Subject: FW: Planning Consultation on: A/122/19/OUT

Comment from Greenspace

APPLICATION NO: **A/122/19/OUT**

Registered: 4th September
2019
Site Address: Land off Arundel Road Angmering BN16 4ET
Grid Reference: 506639 105348

Figure 5.1: Development Framework Plan.

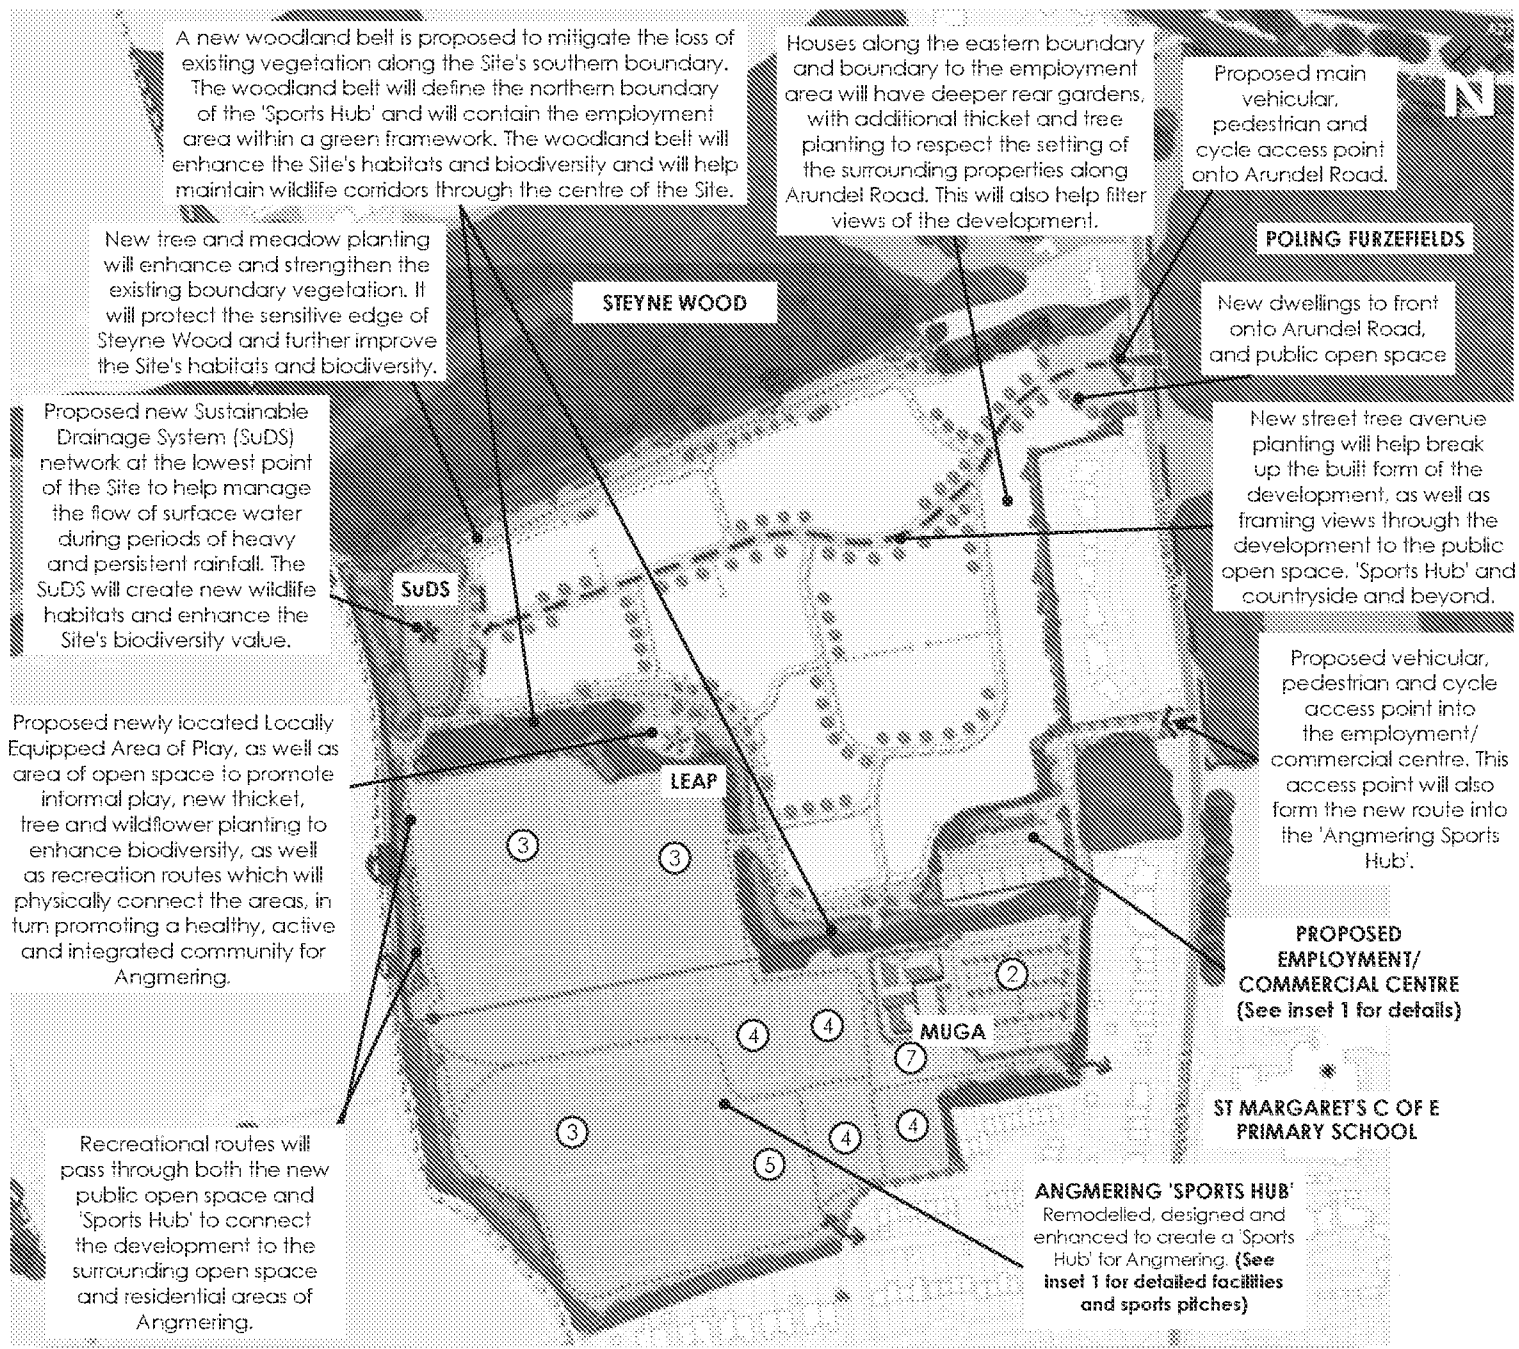
It is unclear from the Development Framework Plan dwg CSA/3467/137 what the spacing and layout of the dwellings within these proposals will be? The connectivity to network paths for walking and cycling and for access within the proposed development and to the community beyond should not be overlooked.
